RE: The White Heart
License Outdoor Seating Violations

Re: 037 Block C016001
License # 2868/Permit 07-0200

This is a complaint against "The White Heart" 551 Congress St., for failure to abide by Outdoor Seating area conditions issued by your office, and sidewalk dimension markers installed by the City of Portland Enforcement Officer

Permit #
090718

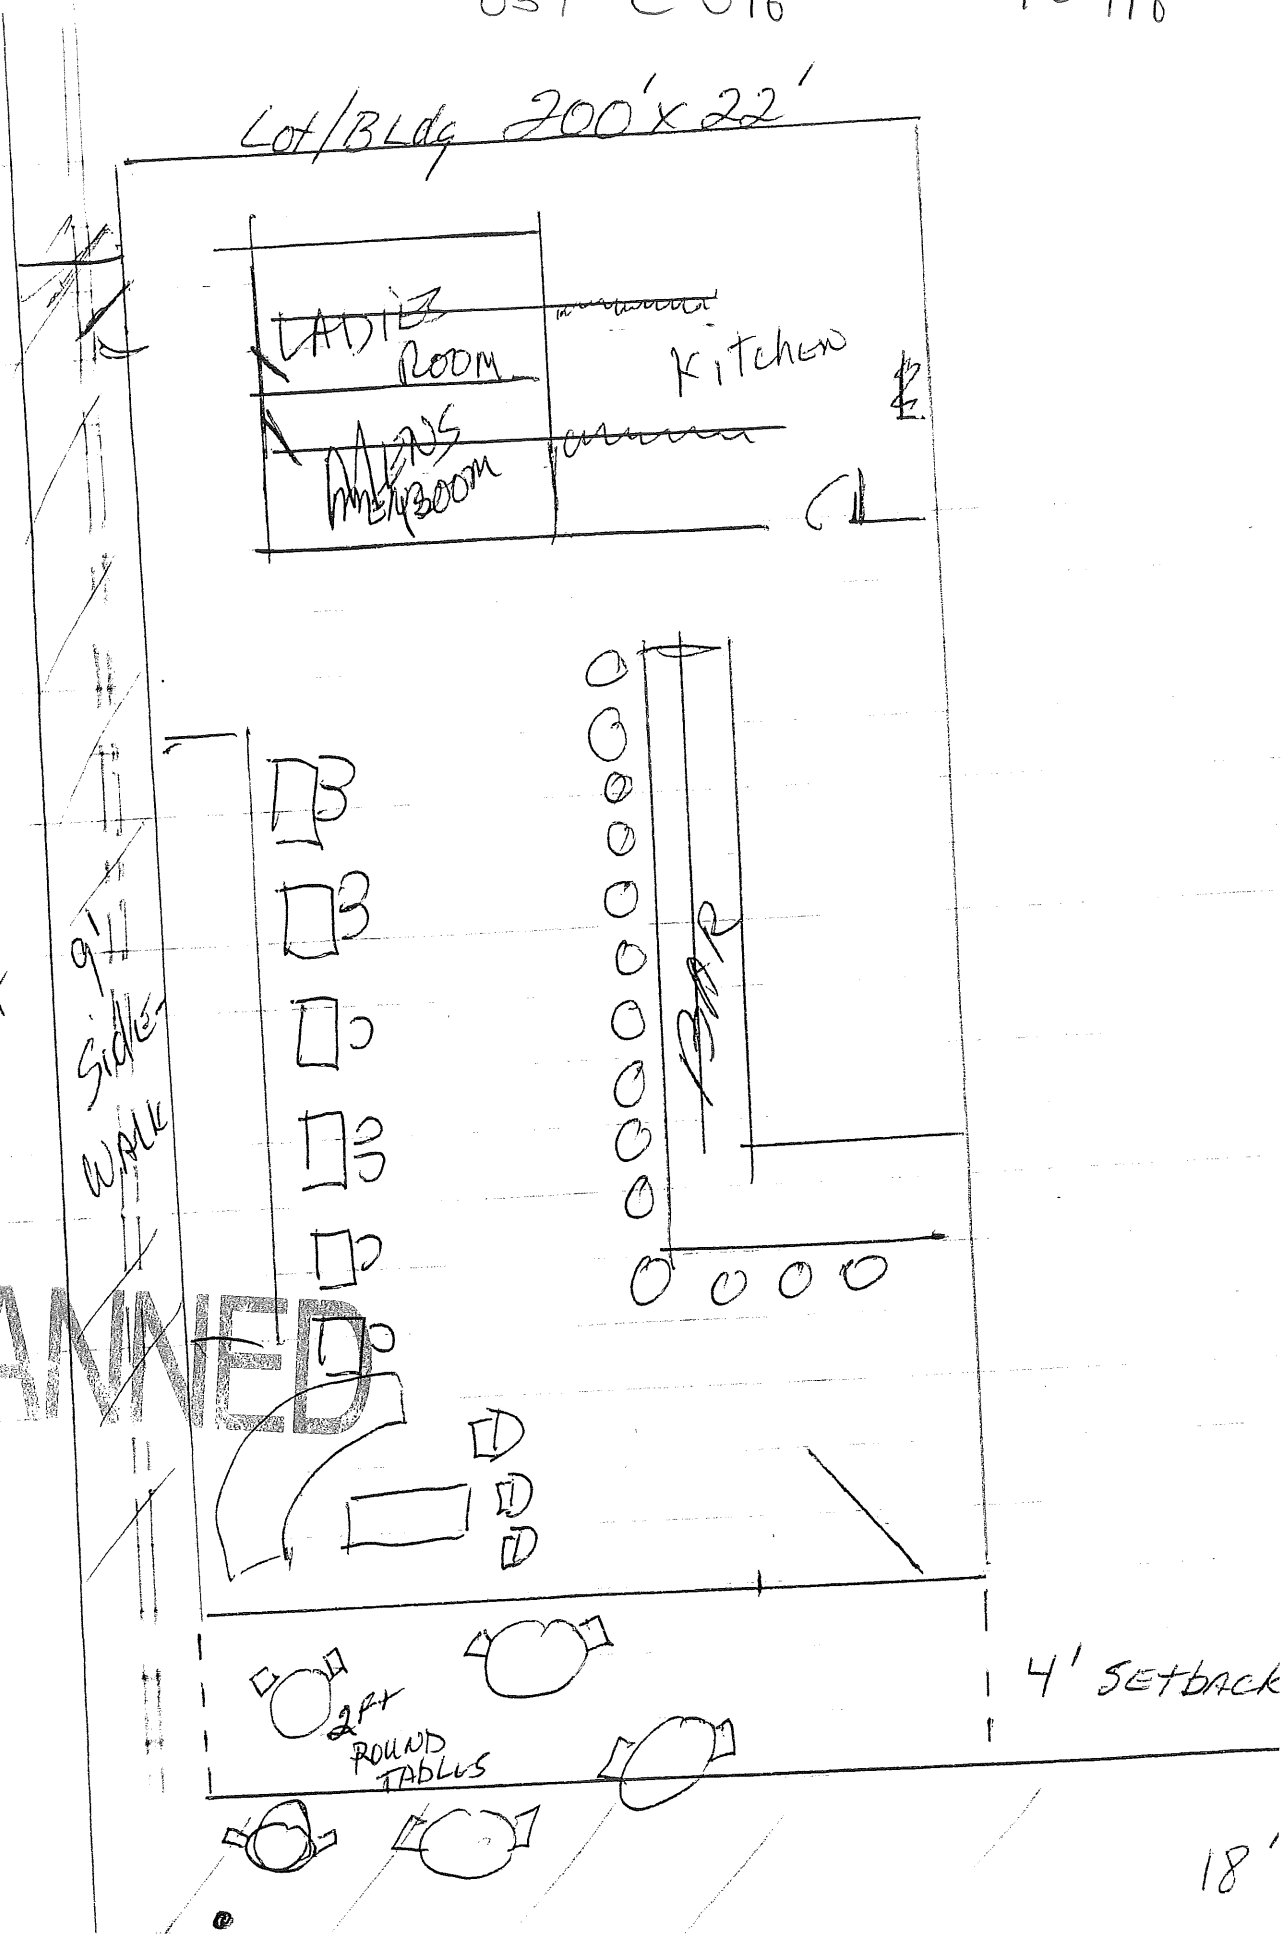
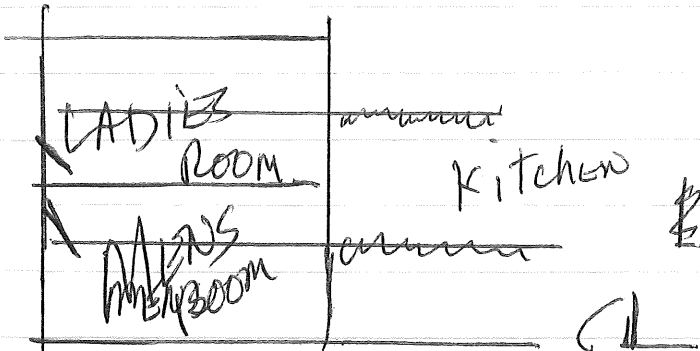
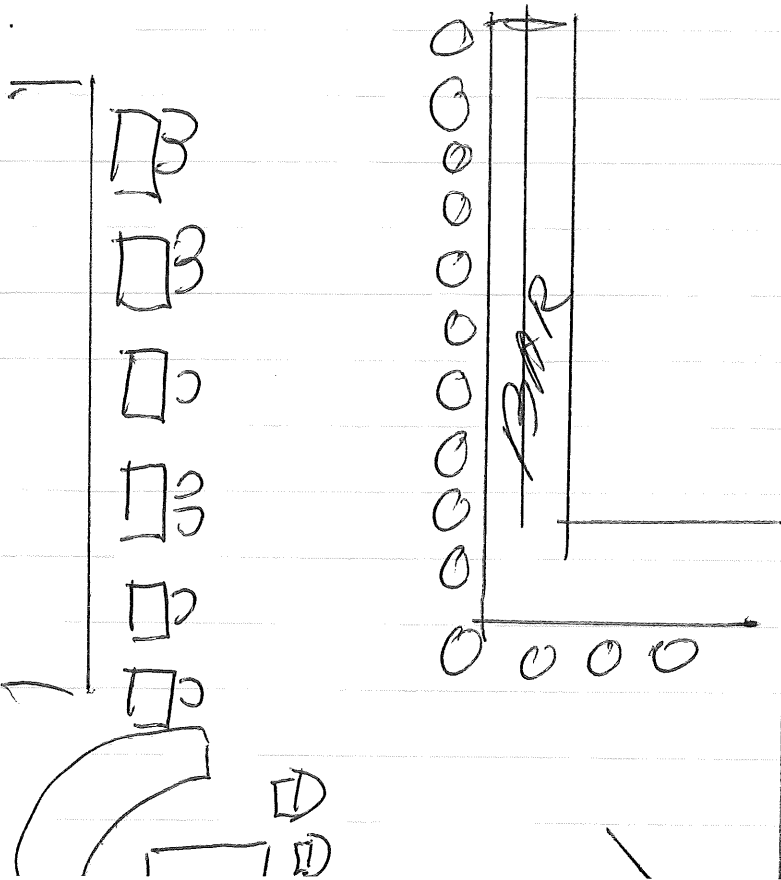
Specifically, The White Heart local manager has continued to block Congress St sidewalk access for pedestrians with excessive outside seating in violation of the drawings submitted for the permit. I have spoken to the local manager and have been ignored.

I have taken a photo on Sun Aug 30th which shows the barricade chain, potted plants and furniture interfering with the OAK ST street pedestrian crossing. I talked about this violation with a manager on Aug 29th. The Aug 30th photo shows that area seating extended to $\frac{3}{4}$ of the sidewalk space interfering with free and safe passage of Congress St pedestrian traffic
